From: Faulkner, Stephen <stephen.faulkner@norfolk.gov.uk>
Sent: 01 February 2019 13:40
To: Norfolk Vanguard
Cc: [REDACTED]
Subject: RE: Local Impact Submission - Norfolk County Council
Attachments: Appendix 1 - Detailed Comments_V2_LLFA.PDF

Further to Norfolk County Council's submission of its Local Impact Report (LIR) below, I have attached an amended Appendix 1 of the LIR, which makes a minor factual amendment to paragraph 1.15 (proposed condition/requirement – surface water drainage).

Response to Norfolk Vanguard DCO Application - Detailed Environmental, Highway and Flood Risk Comments

**Table 20.1 Detailed watercourse crossing schedule**

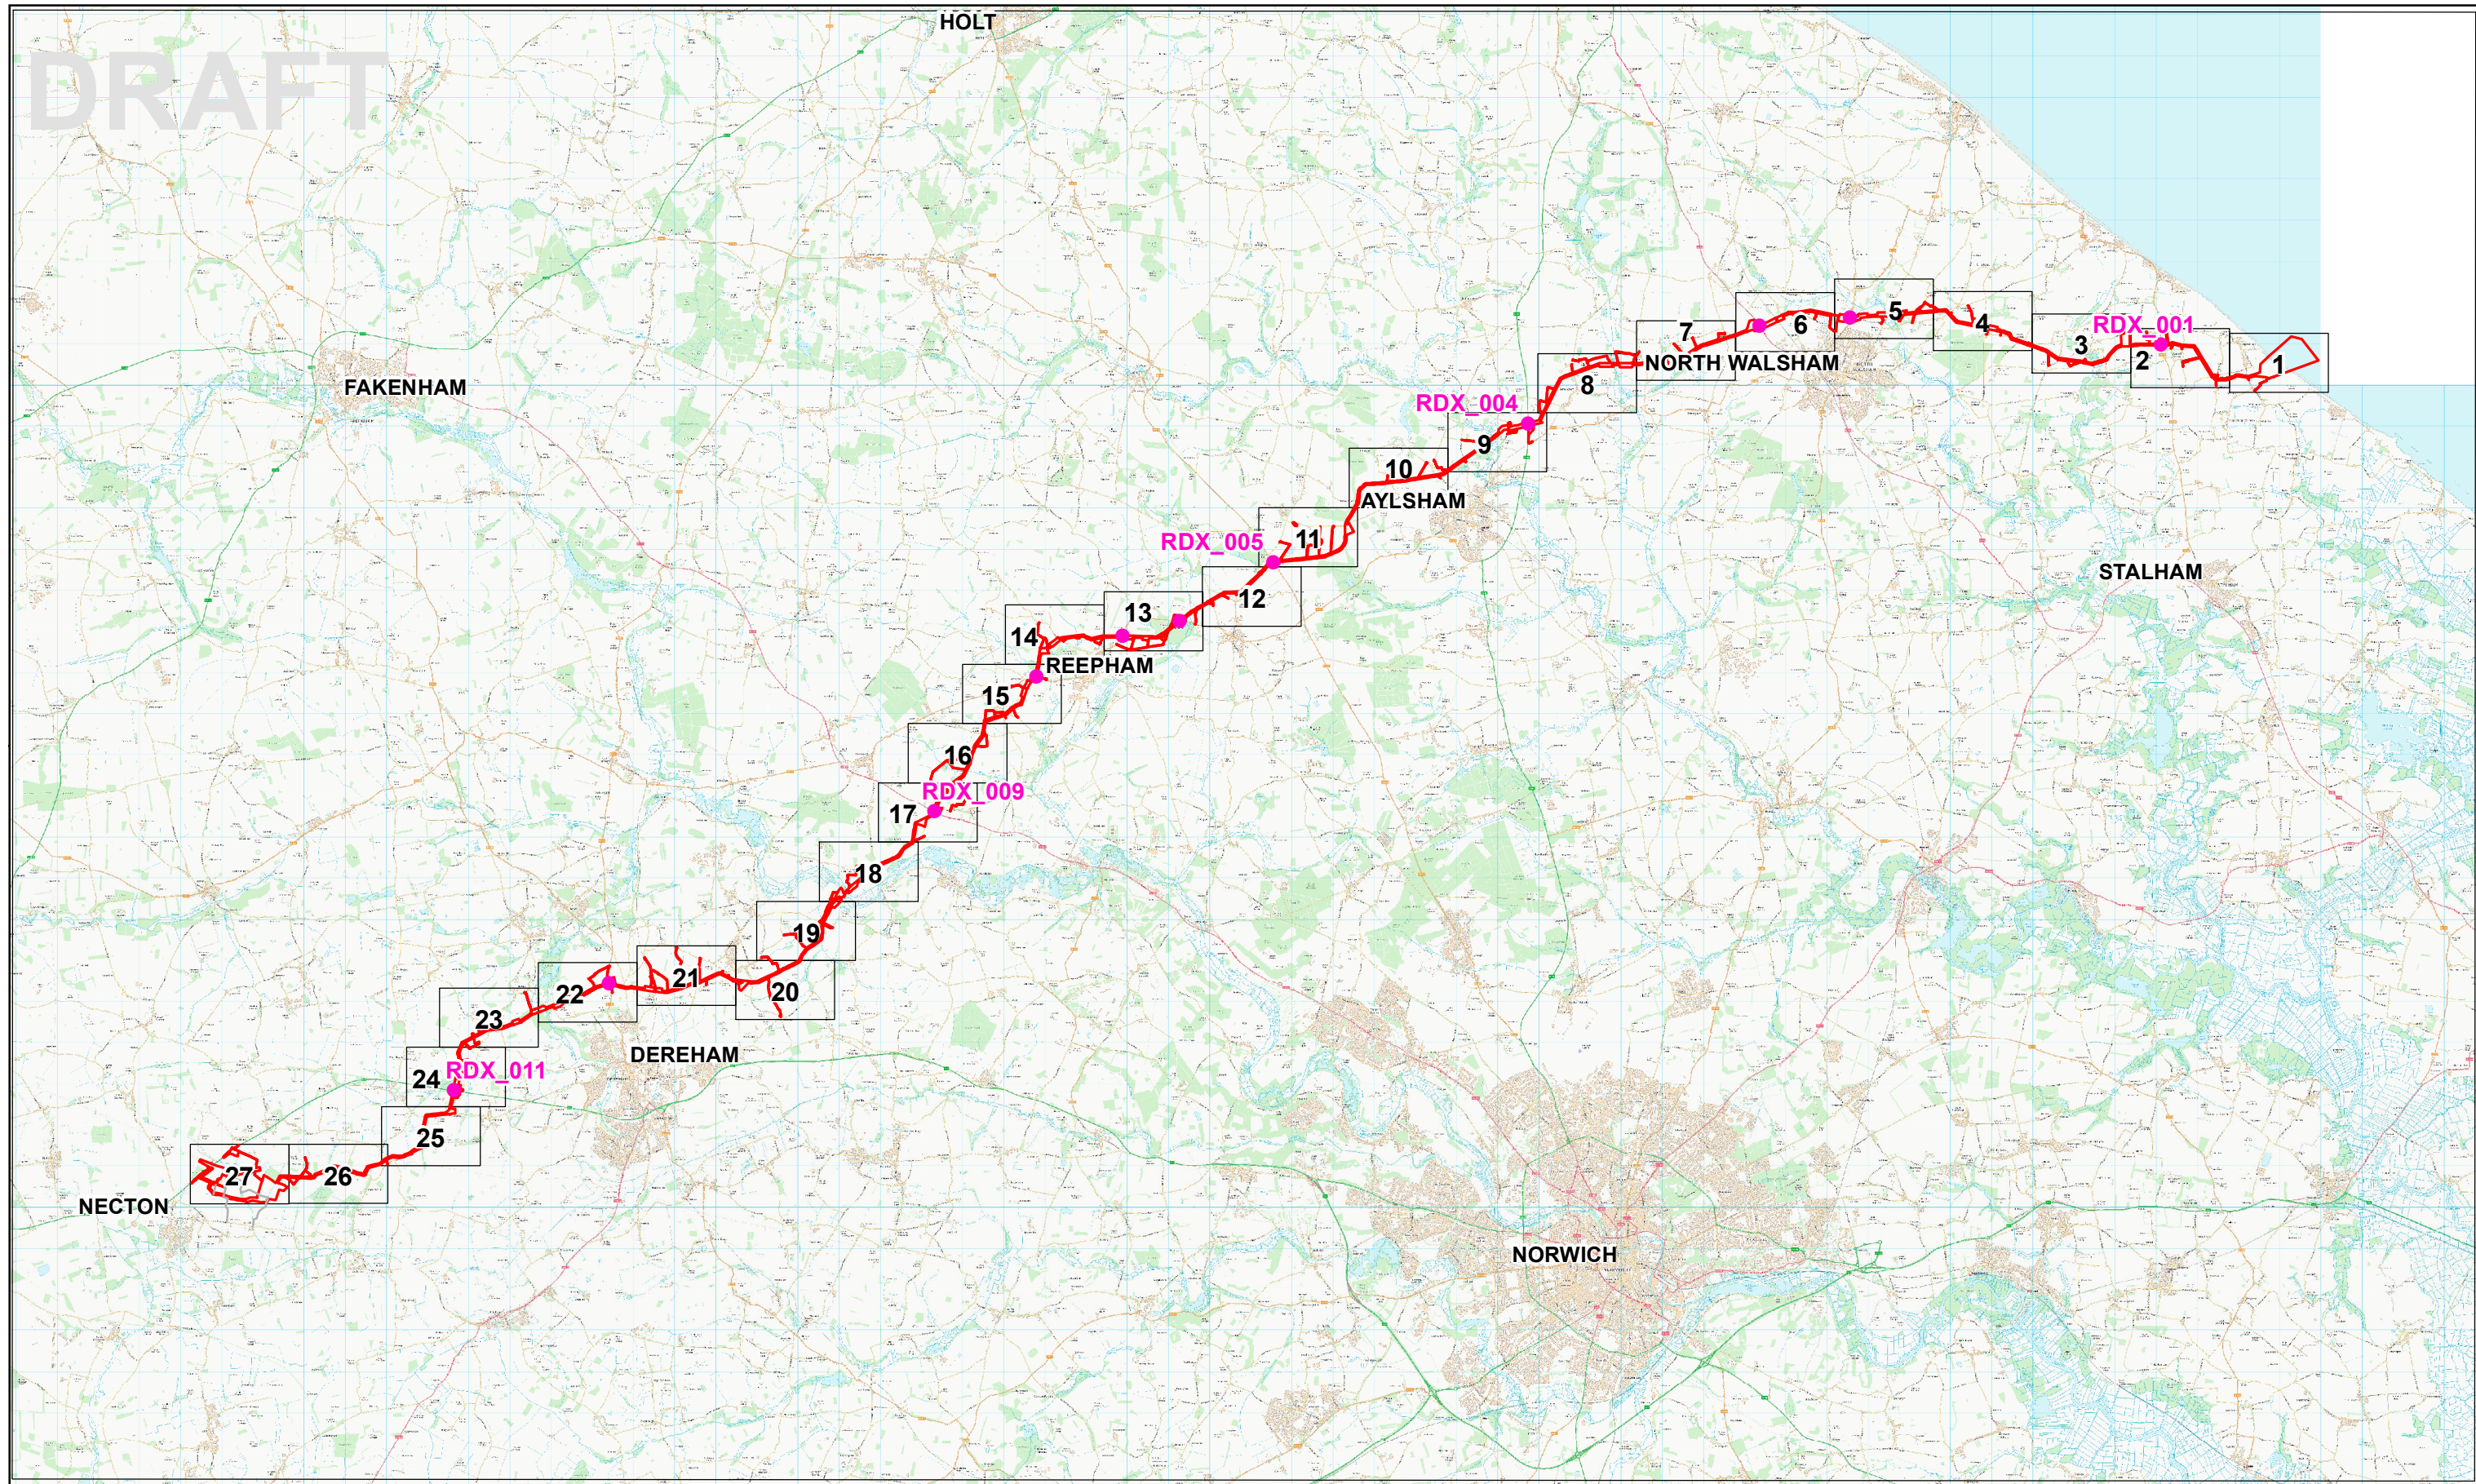
- 1.14. The ES states that the crossing of ordinary watercourses would be by Horizontal Directional Drilling (trenchless) or open cut. Referring to Appendix 20.4 Detailed Watercourse Crossing Schedule Table 20.1 it is noted that it appears that the majority all Norfolk County Council ordinary watercourses are proposed to be crossed by open cut rather than Horizontal Directional Drilling for permanent works. If this is the case, or any other temporary works proposed as part of this project are likely to affect flows in an ordinary watercourse, then the applicant would need the approval of Norfolk County Council. The County Council would appreciate early consultation on the number of such crossings of Ordinary Watercourses and the required timeframes for approval. This will enable the team to have adequate staffing resources in place to ensure approvals are not unduly delayed and for and issues to be identified. It is also noted that other ordinary watercourse crossings would need consent approval from the relevant Internal Drainage Board (IDB). In line with good practice, Norfolk County Council seeks to avoid culverting, and its consent for such works will not normally be granted except as a means of access. It should be noted that this approval is separate from planning and temporary mitigation methods may be required while cable laying is undertaken.

Drawing file: published-documents / EN010079-001659-Figure 4.13 Onshore Project Substation and National Grid Substation Extension.pdf

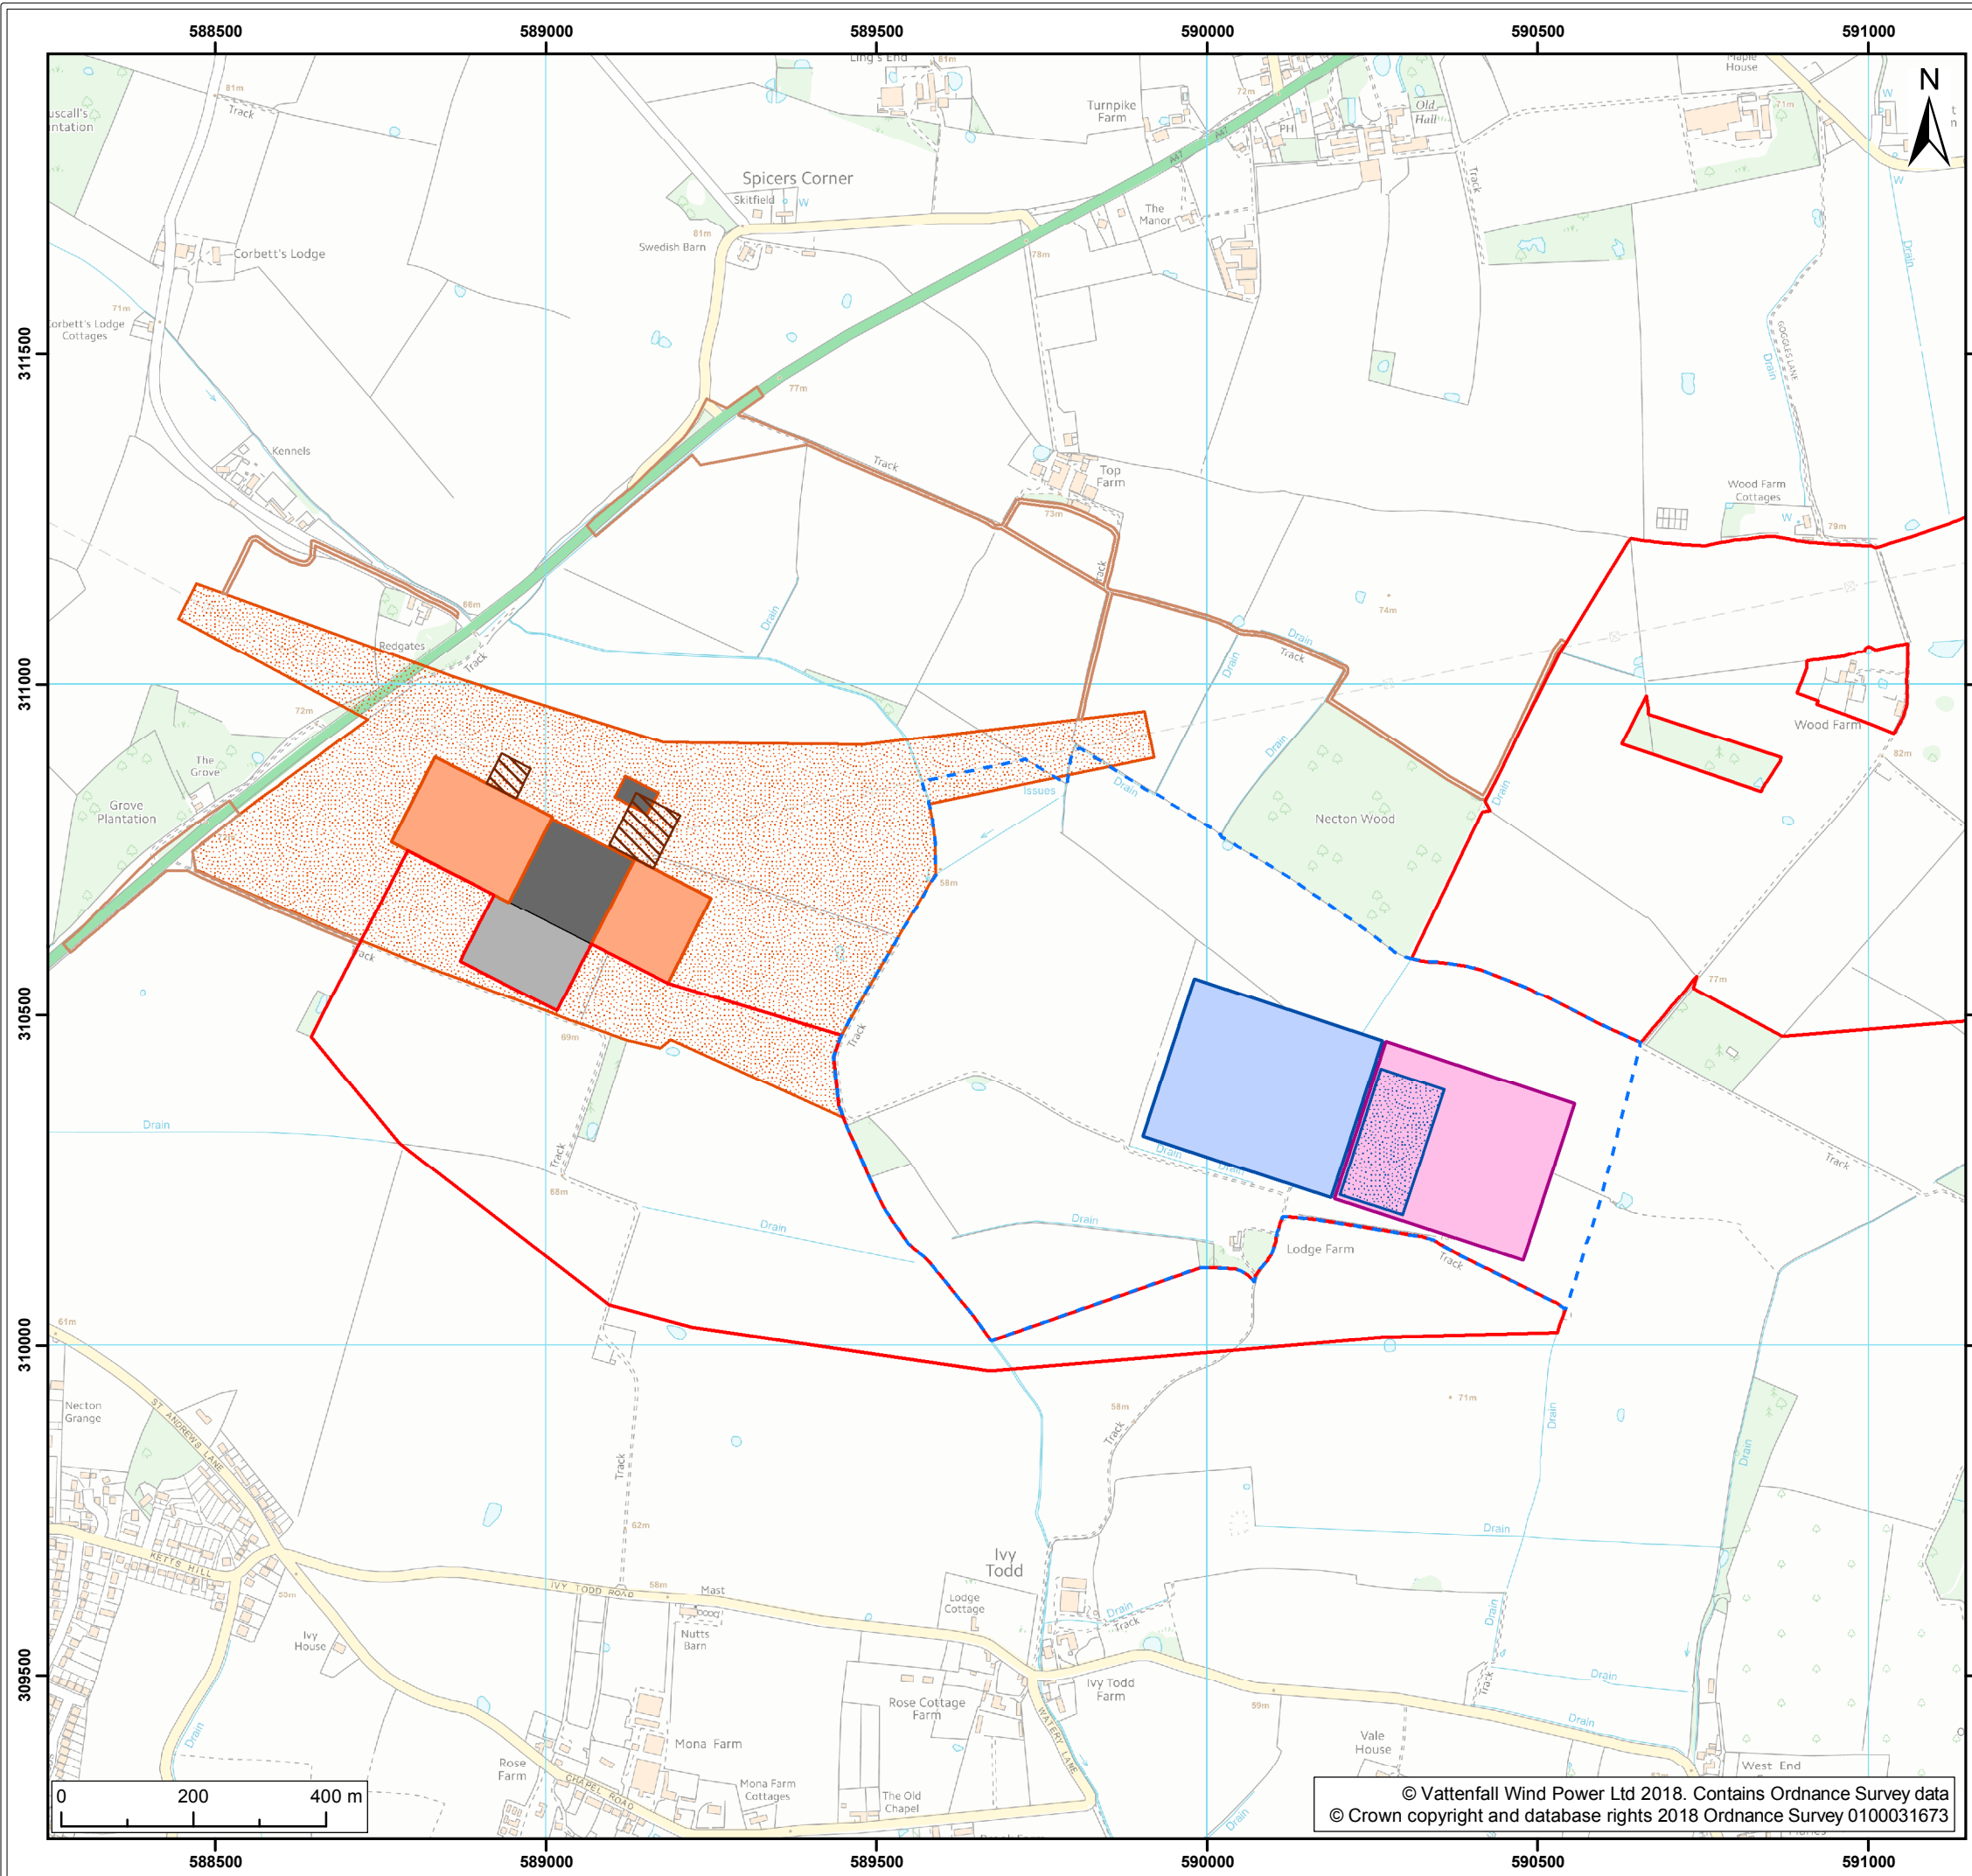
- 1.15. Prior to commencement of development, in accordance with the submitted Environmental Statement for Application for Development Consent - The proposed Norfolk Vanguard Offshore Wind Farm, detailed designs of a surface water drainage scheme incorporating the following measures shall be submitted to and agreed with the Secretary of State or his delegated approving body. The approved scheme will be implemented prior to the first use of the development. The scheme shall address the following matters:

- I. Detailed infiltration testing to be undertaken in accordance with BRE Digest 365 within the study areas for the sub-station and the National Grid sub-station extension for the design of SuDs features.

- VII. Finished ground floor levels of the converter / booster station and substation should have a freeboard such that all infrastructure is above expected flood levels from all sources of flooding, including fluvial flooding associated with the ordinary watercourse, tidal flooding and any above ground storage or flooding from the proposed drainage scheme.
